**KIRKLEES METROPOLITAN COUNCIL
INVESTMENT & REGENERATION SERVICE**

DELEGATED DECISION TO DETERMINE PLANNING APPLICATIONS

Reference No:	2024/62/90389/W
Site Address:	25, Ivy Street, Crosland Moor, Huddersfield, HD4 5RB
Description:	Erection of staircase to front elevation with replacement porch roof and alterations (retrospective)
Recommending Officer:	Laura Yeadon

DECISION - REFUSE

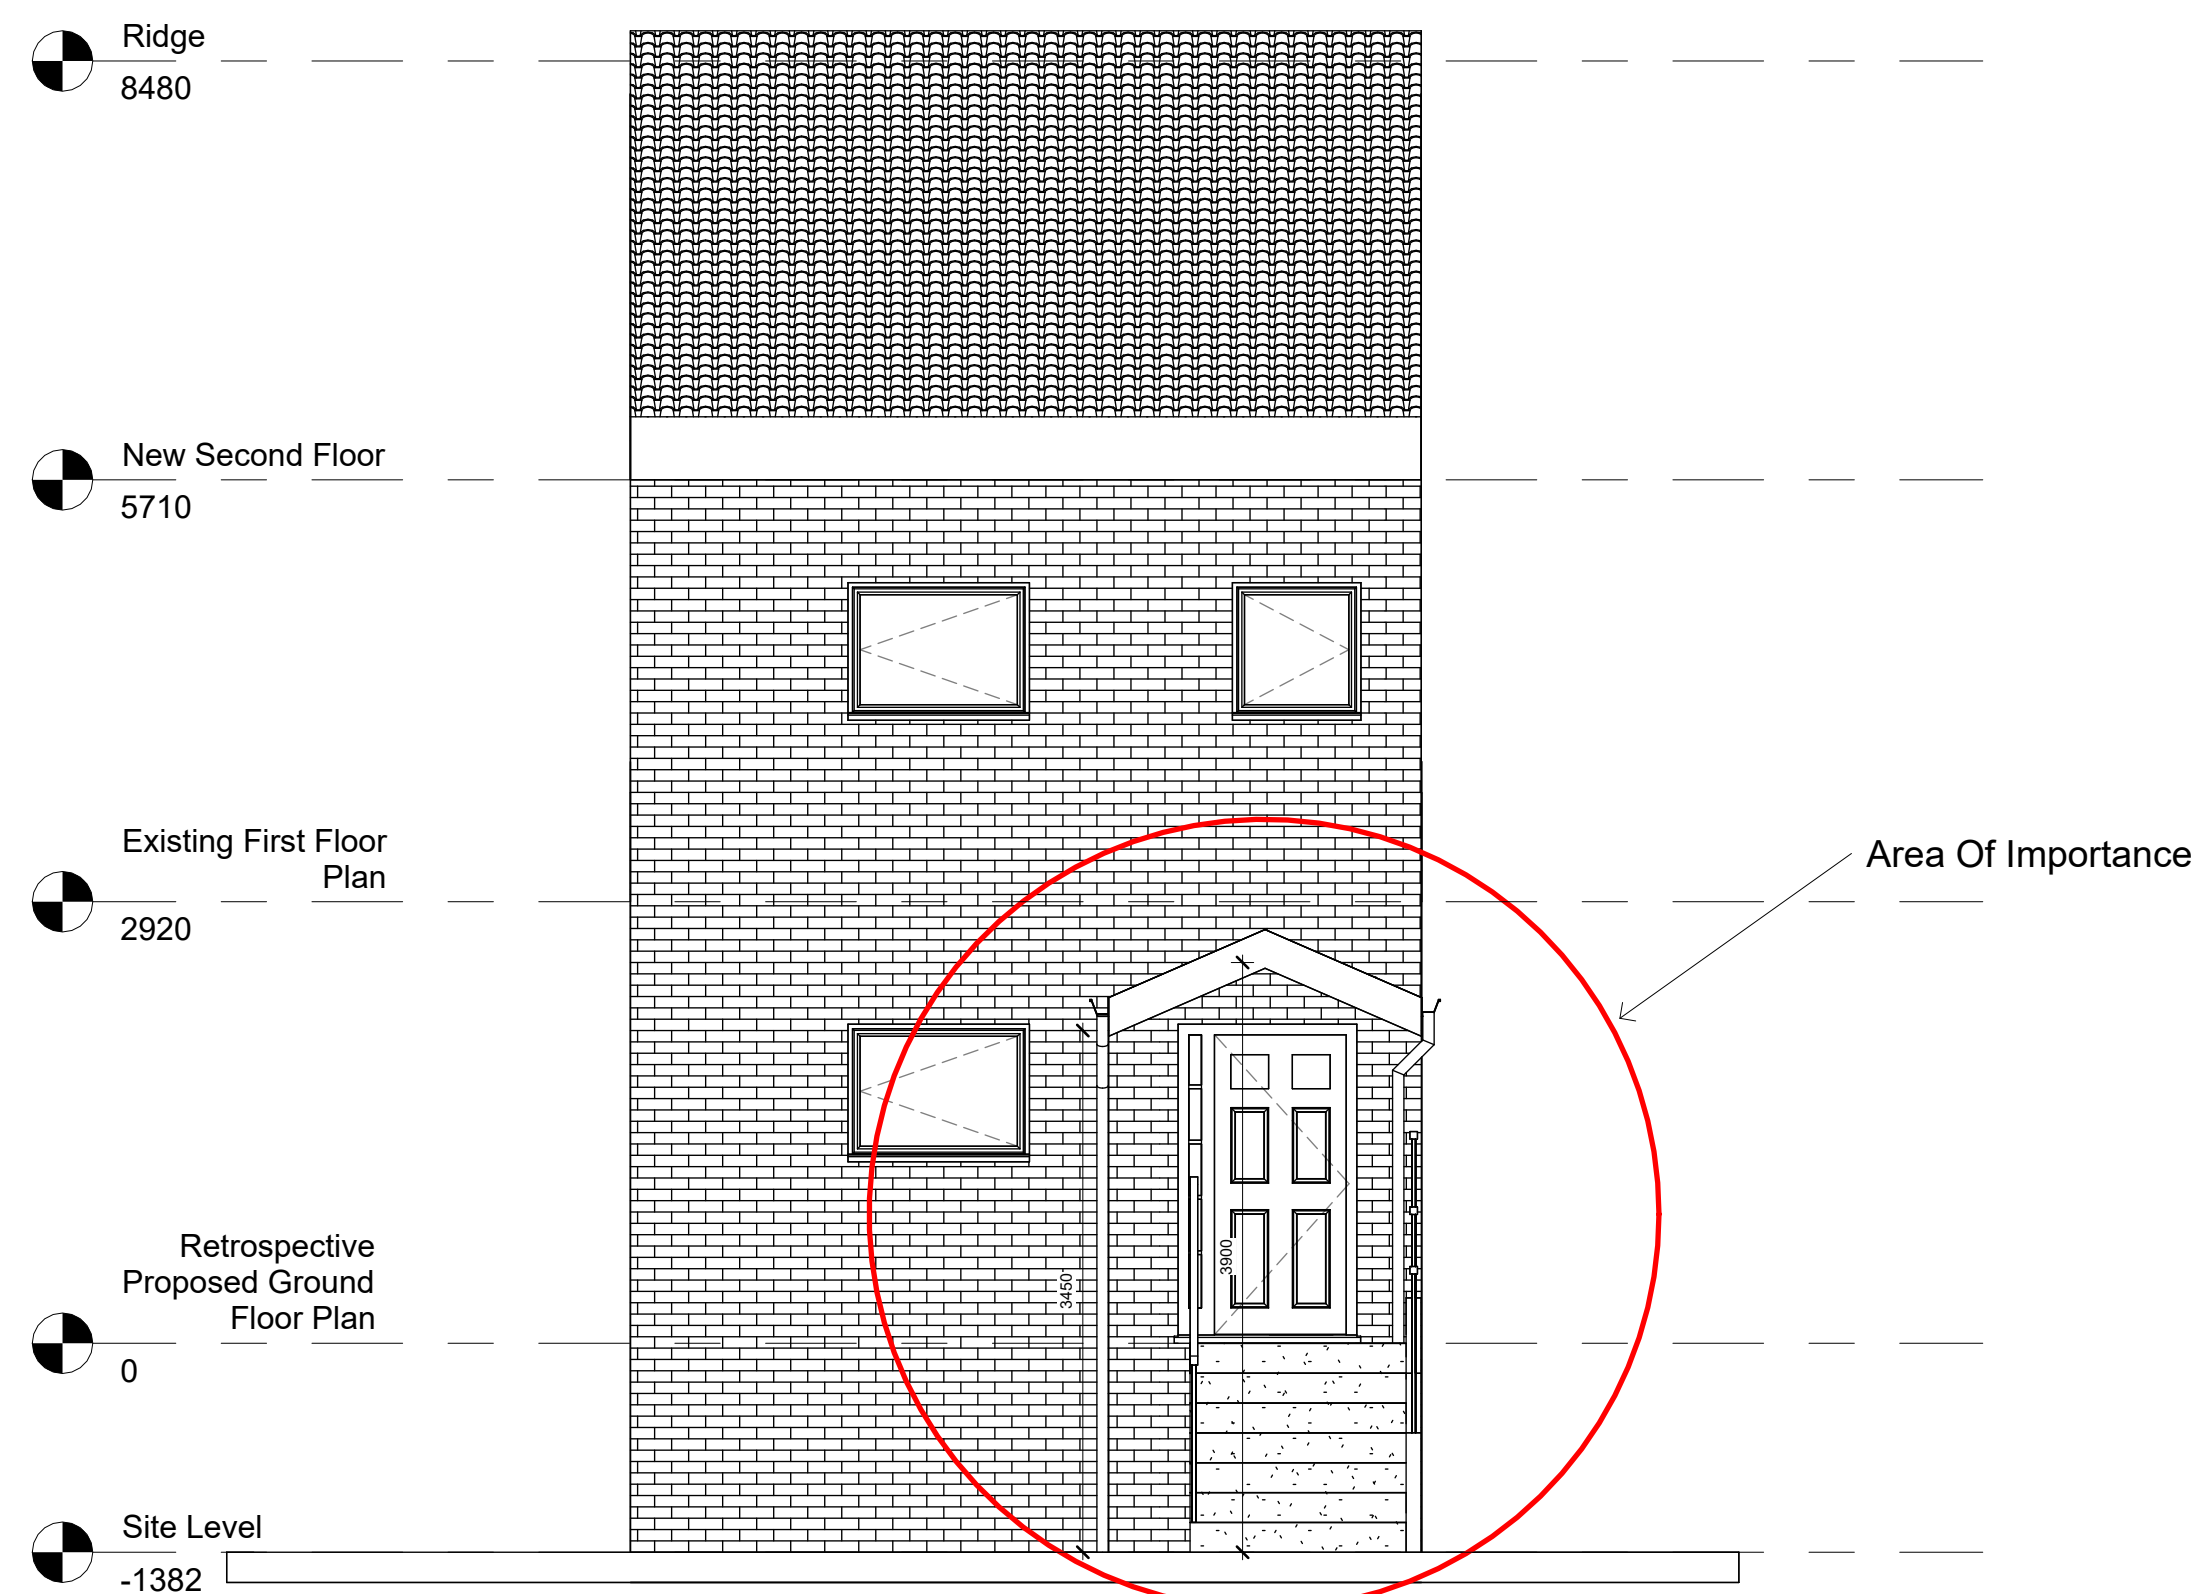
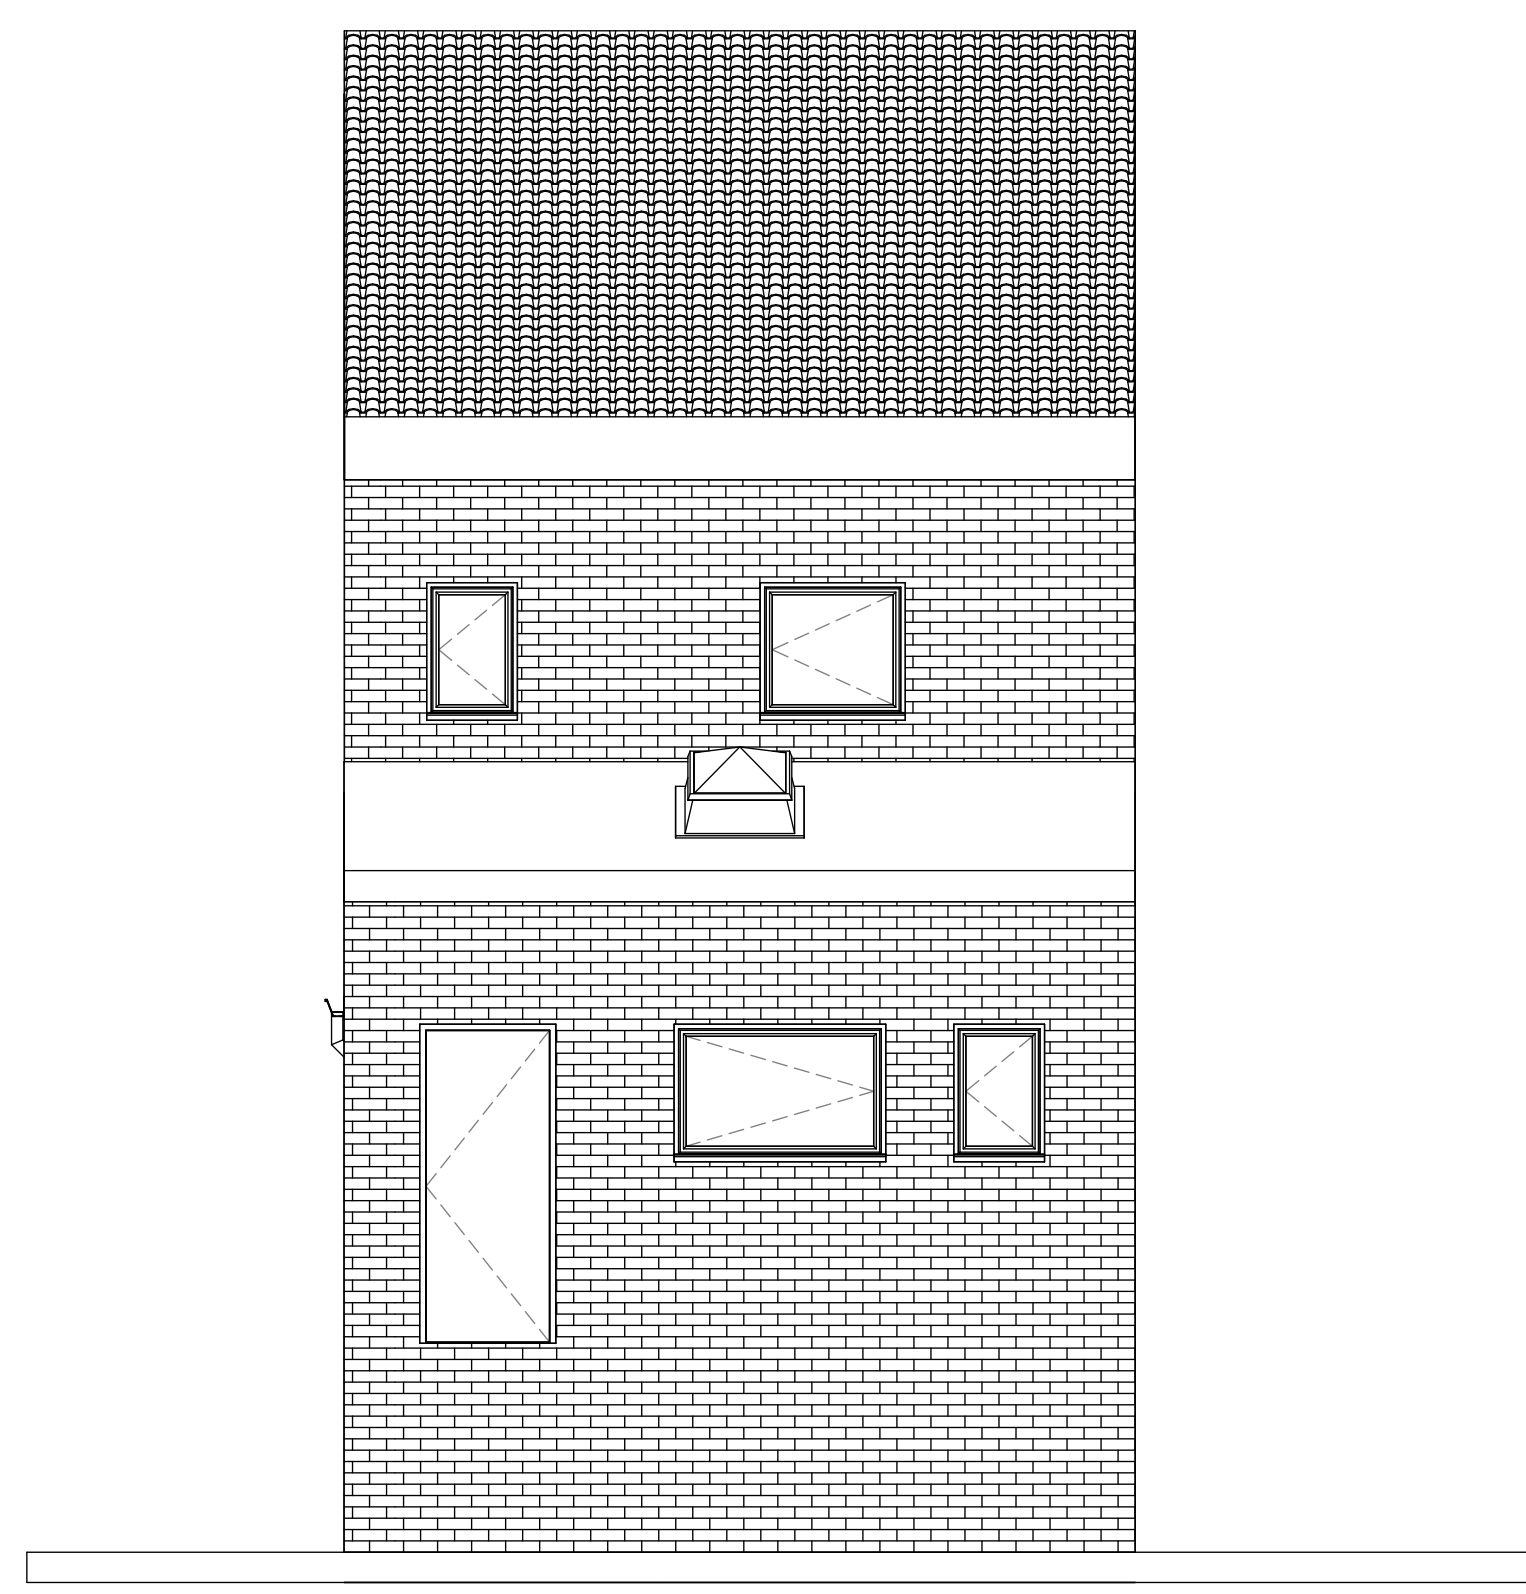
The creation of the staircase extends forward of the front elevation of the porch by an additional 2.6 metres which results in a prominent structure within the street scene. There is a uniformity of flush front elevations within the terraced row which does not host any other front porches. Due to the prominence and depth of the staircase, in conjunction the pitched roof which has more visual

impact than the simple lean-to roof as previously approved, the works in totality would detract from the visual amenity of the area and forms an overly prominent and incongruous feature with a resultant adverse visual impact that would be contrary to Policy LP24 (a) of the Kirklees Local Plan. This Policy states that the form, scale, layout and details of all development should respect and enhance the townscape. This is further supported by the House Extensions and Alterations SPD which states that front extensions are highly prominent in the street scene and can erode the character of the area.

It is therefore considered that the cumulative impact of the staircase and alterations with the change of roof form would fail to comply with Policy LP 24 (a and c) of the Kirklees Local Plan, Key Design Principles 1 and 2 of the House Extensions and Alterations SPD and advice within Chapter 12 of the NPPF.
